Please upload onto Ocella the following emails from the applicant and the revised plans (attached) and listed below to discharge of condition application **Y/139/20/DOC**.

- Designer's Response to Road Safety Audit Stage 1&2: Temporary Construction Access, Ford Lane, Yapton, West Sussex (Ref. **18-344-14 Rev. B**), prepared by Odyssey, January 2021.
- Drawing No. 18-344/700 **Rev. D** - Agreement Plan.
- Drawing No. 18-344/701 **Rev. F** - General Arrangement.

Scale 1:200 @A1	Date SEP 20	Designed JA
Drawn JA	Checked SG	Approved LH
Job No 18-344	Drawing No 18-344/702	Rev B

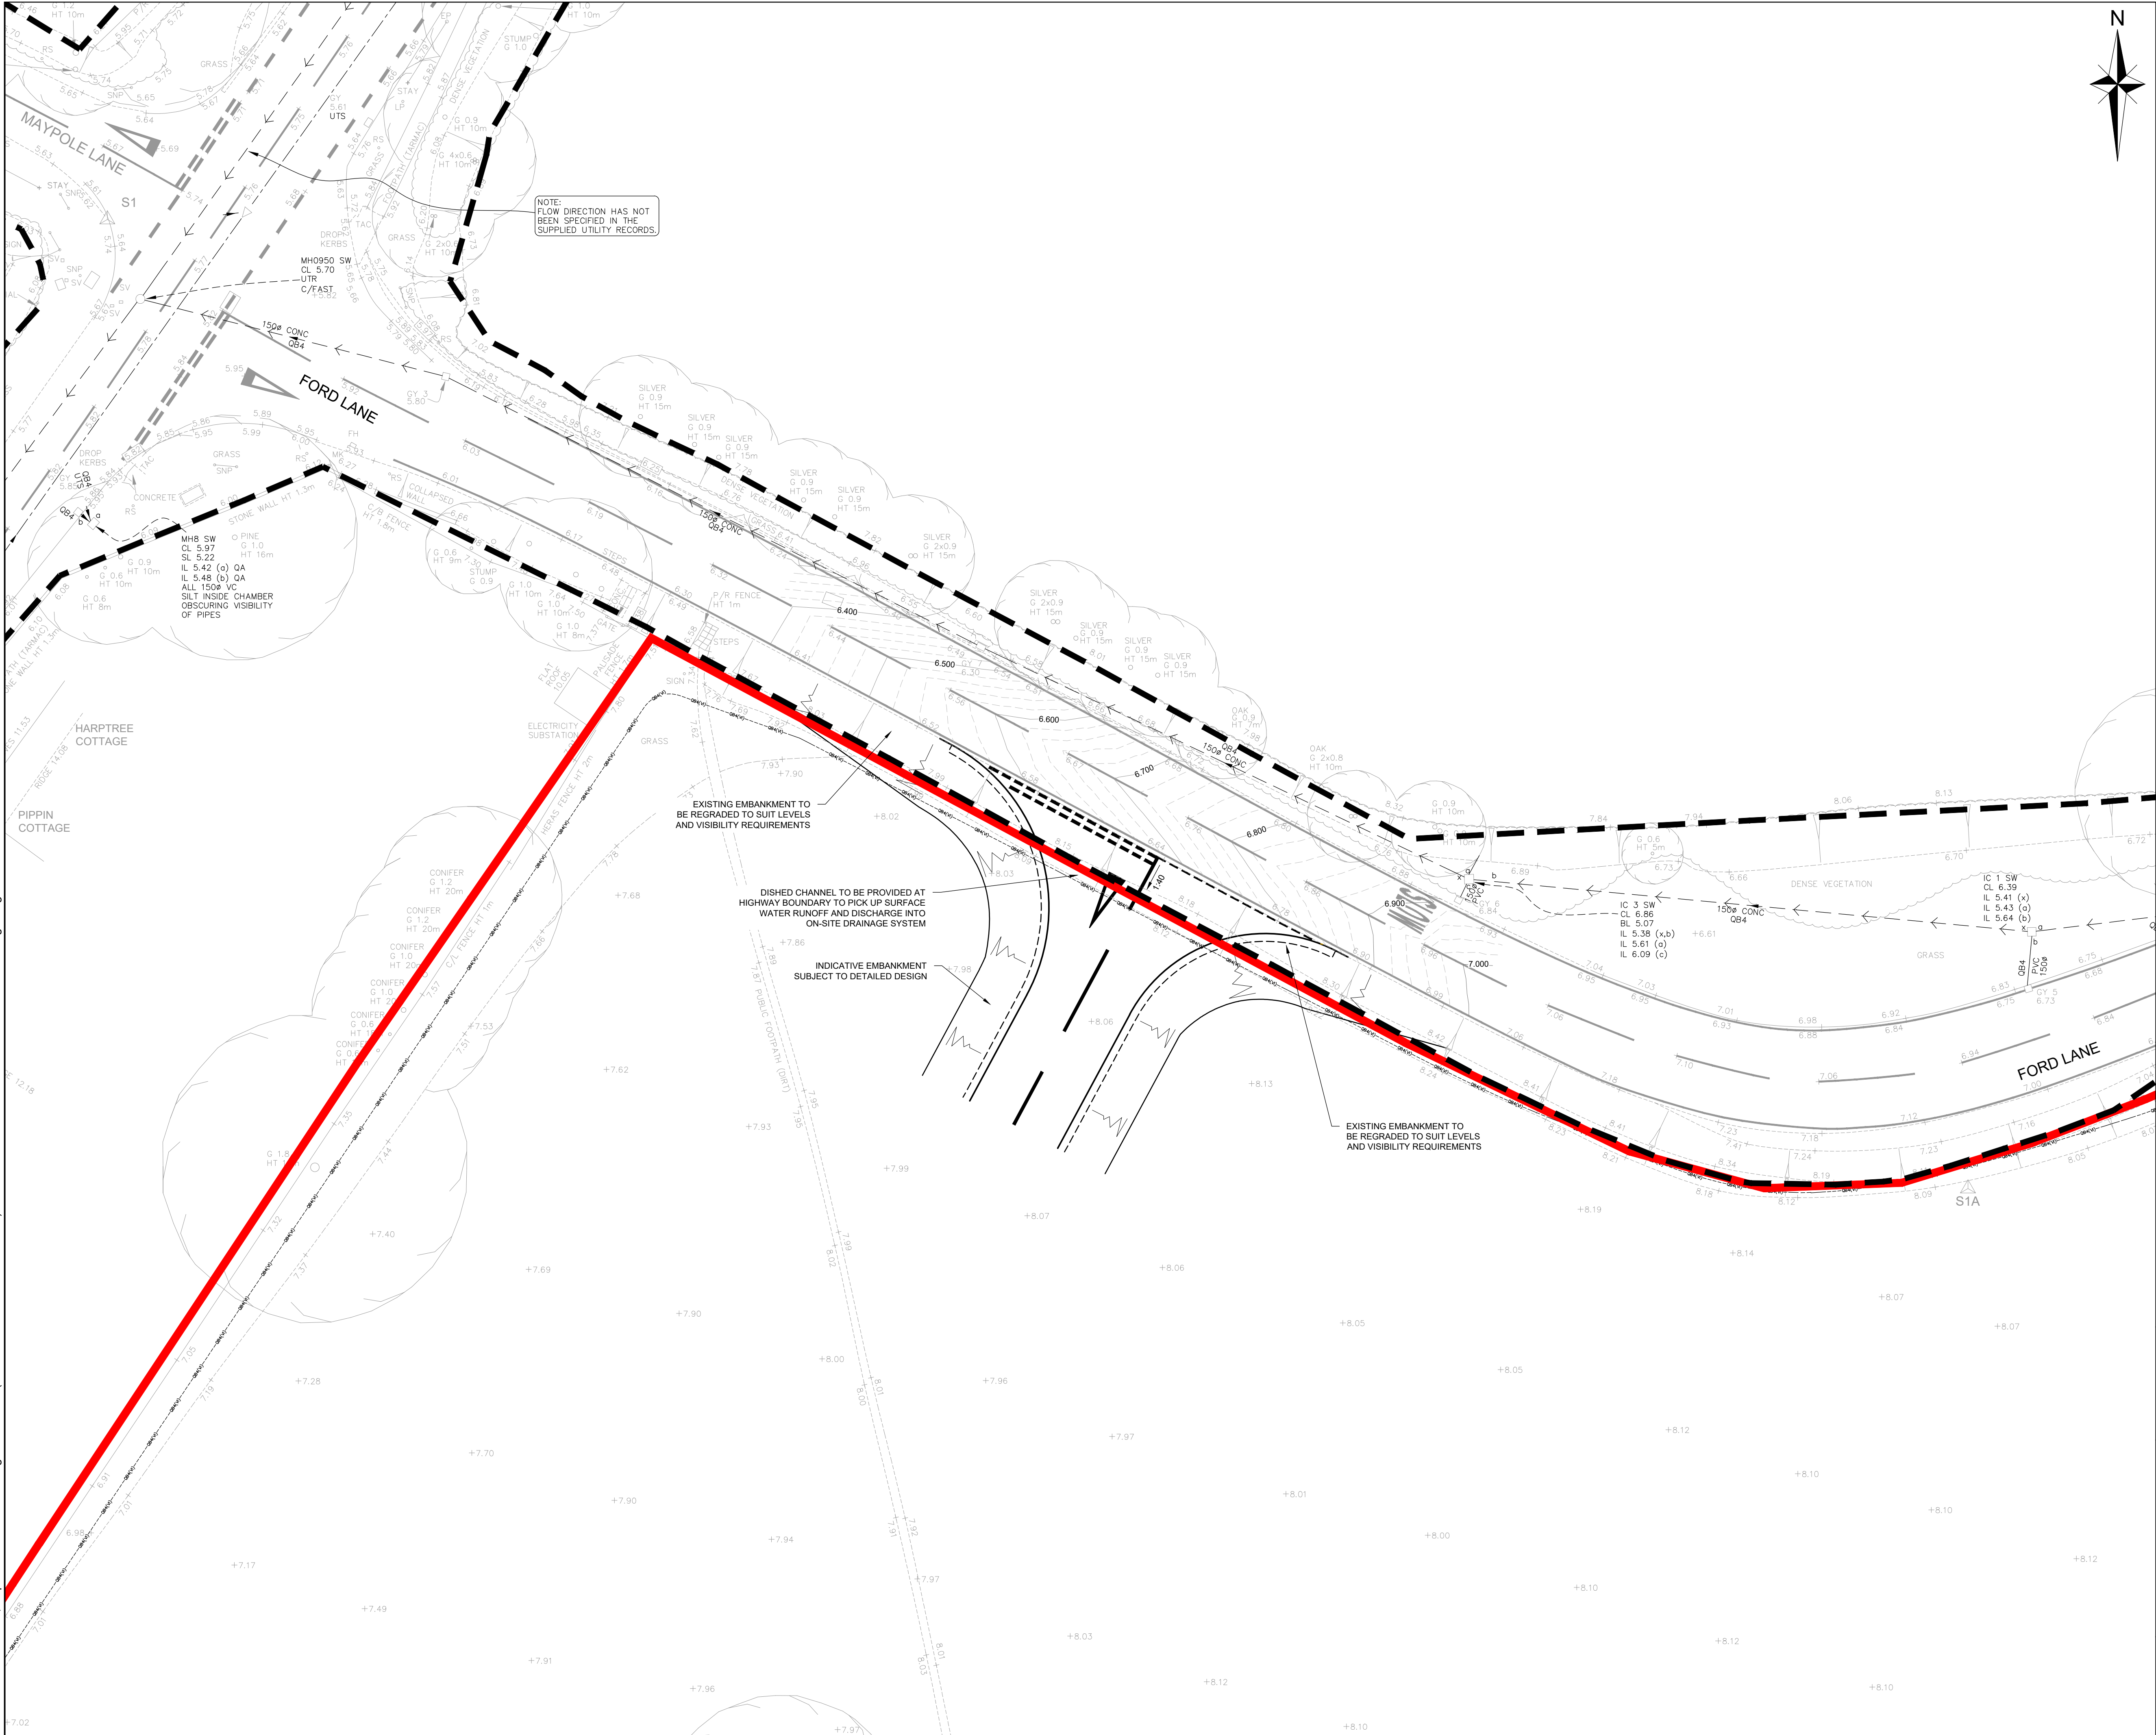
- 1. Reason for access confirmed by Tilly Whishaw.*
- 2. Drainage details acceptable - will be checked in further detail as part of S38/278 stage.*
- 3. Designer's Response requires updating to reflect current position.*
- 4. Further information in support of visibility splays as requested previously still NOT provided.*

- Drawing 18-344-701E -- Construction Access General Arrangement shows the updated visibility splays in line with the speed survey results and addresses point 3.3.1.
- Drawing 18-344-702B - Construction Access Levels and Drainage, shows the updated levels and drainage proposals to address point 3.1.1 and this approach was agreed with Lee Moses prior to the update.

Scale	Date	Designed
1:200 @A1	AUG 20	SG
Drawn	Checked	Approved
JA	SG	LH
Job No	Drawing No	Rev
18-344	18-344/701	F

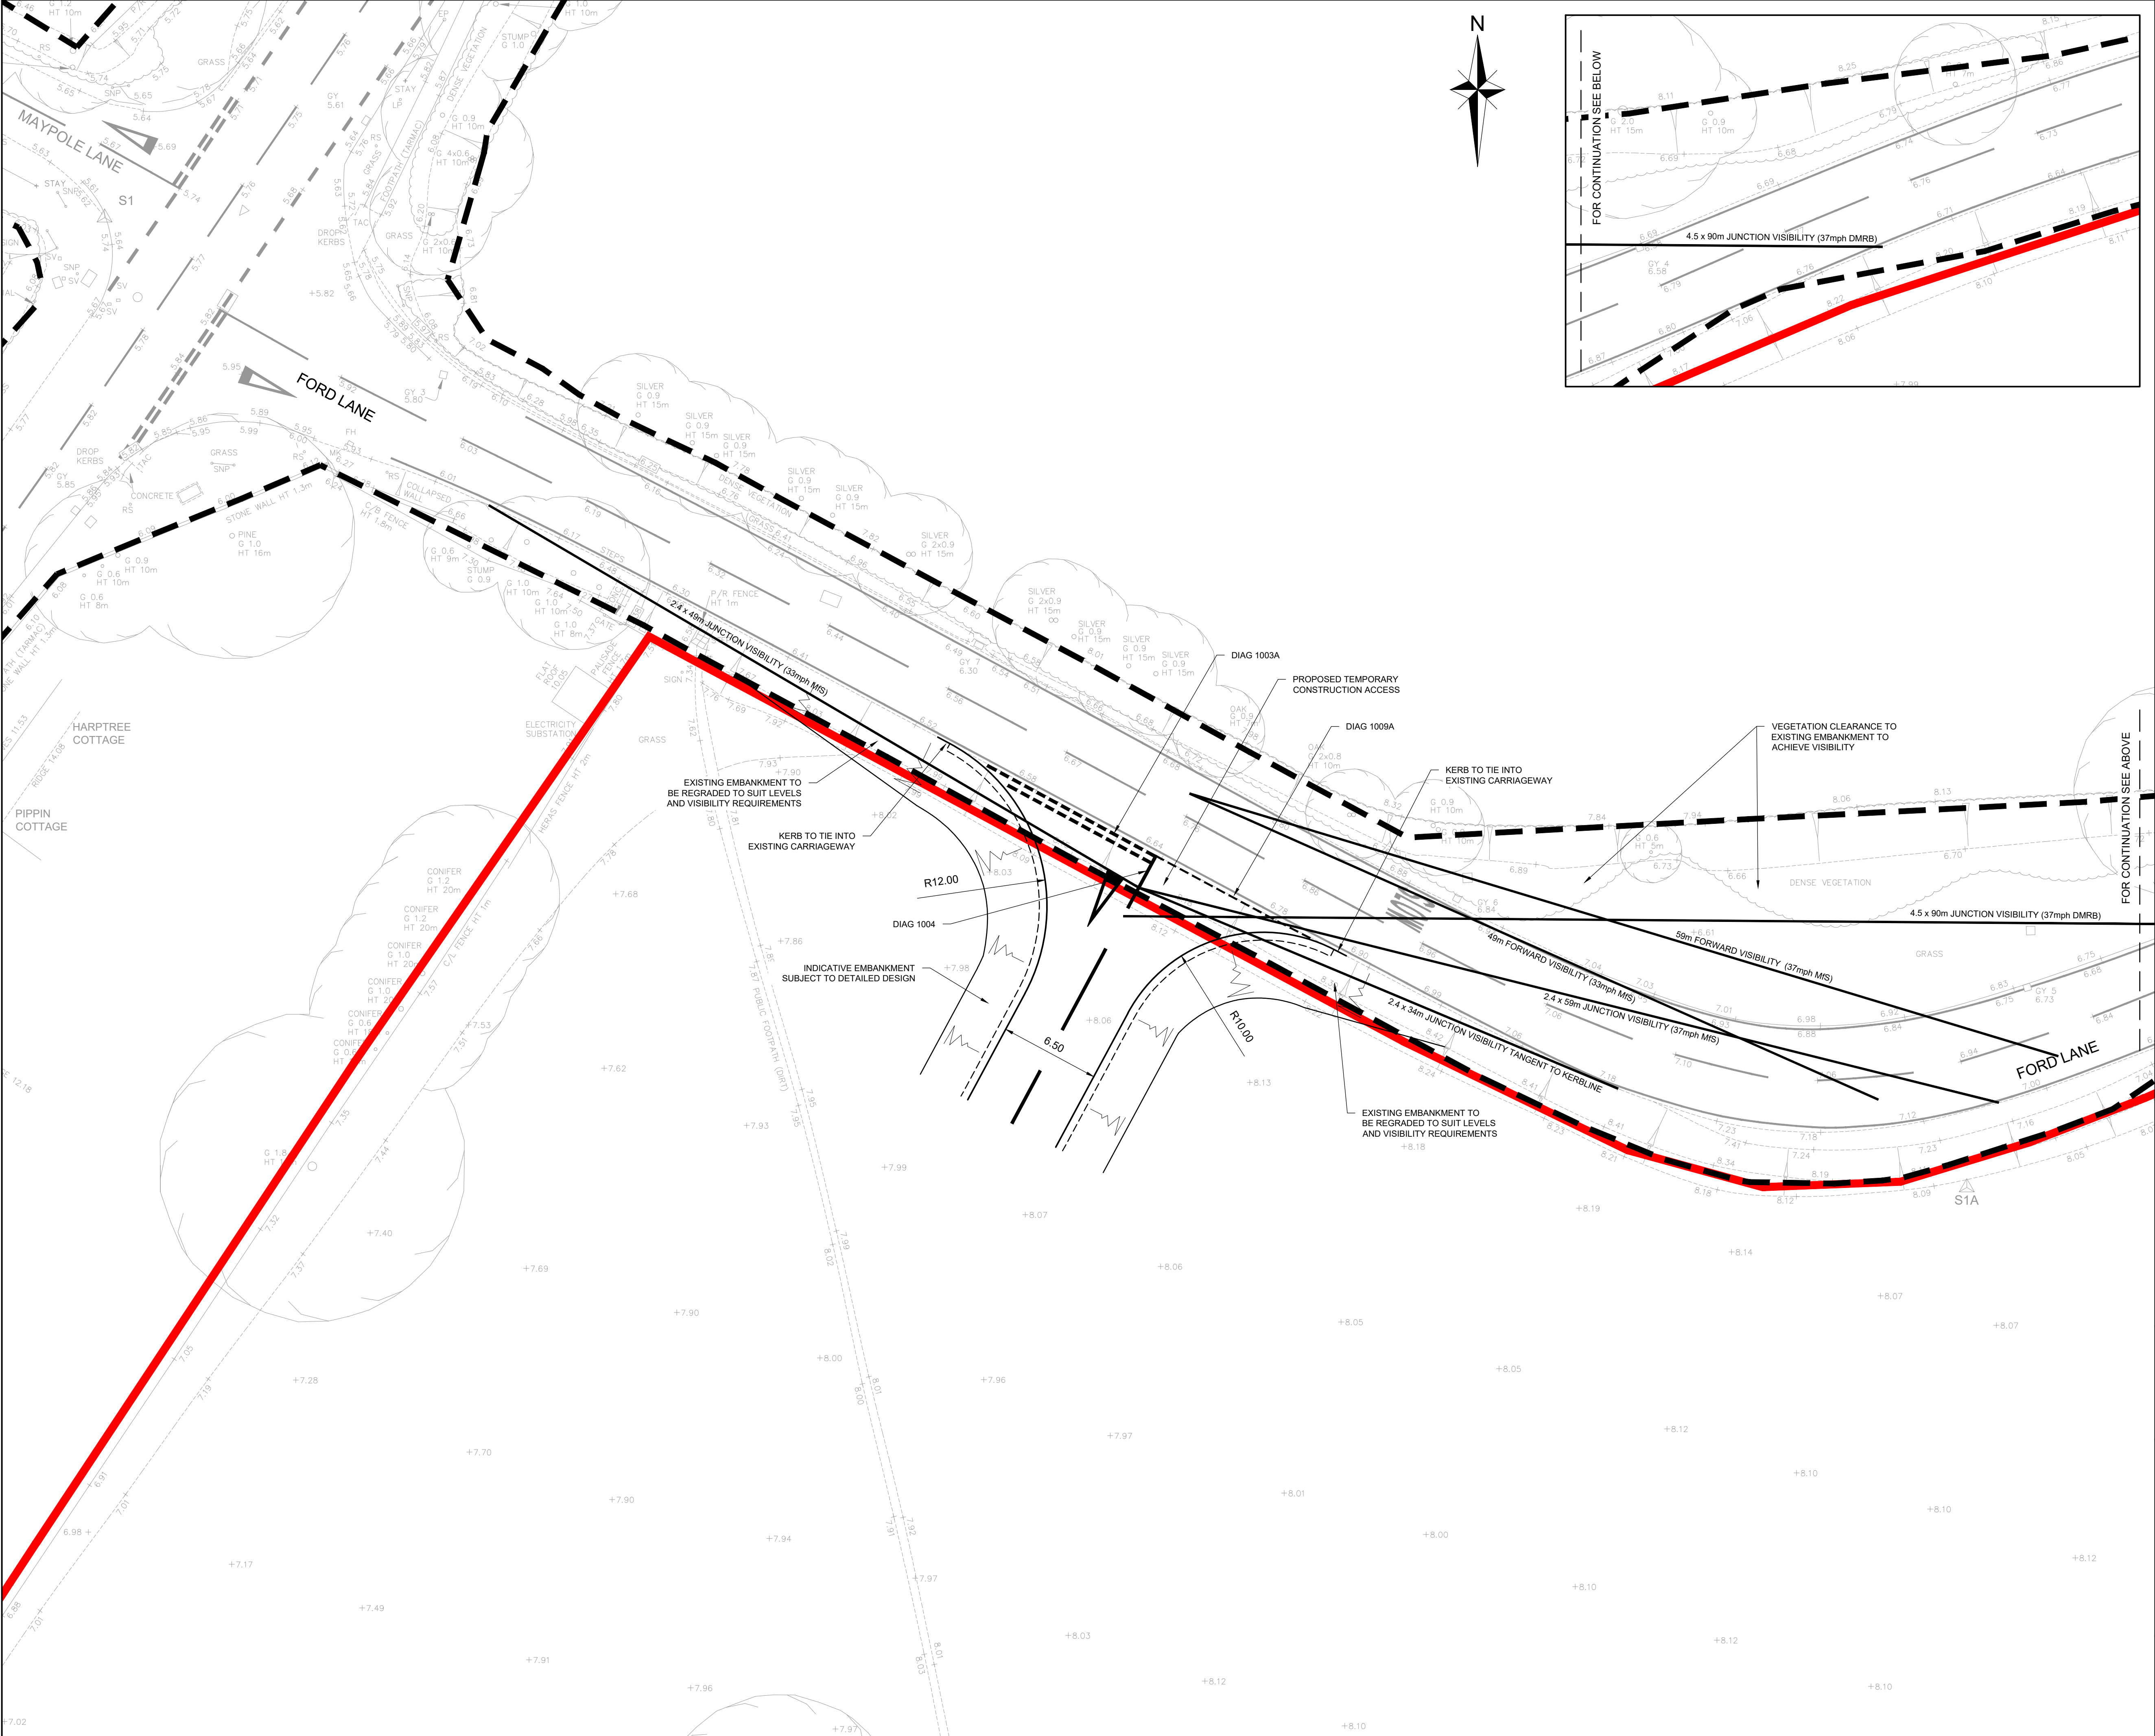
2. *Visibility splays (including forward visibility)* – The site access visibility splay in the leading traffic direction is correct at 59m based on the recorded 85% tile speed of 37mph as shown in the spreadsheet. However, the *forward* visibility splay is only shown at 52m (so 7m short). I note that some vegetation is present on the north side of the road. Can this be trimmed back to provide the full 59m and shown as such on an amended plan? If not, you would have to apply for a Departure from Standard (DfS) which will add further delay to this component of the proposal as it will need consideration by others. Any DfS would also need to be documented in the RSA Log.

To cover off point 2, please find attached, updated drawings showing 59m forward visibility splays. I will arrange for this to be set out on site this week and our Commercial department to get a works order in place for the trimming to be done asap.
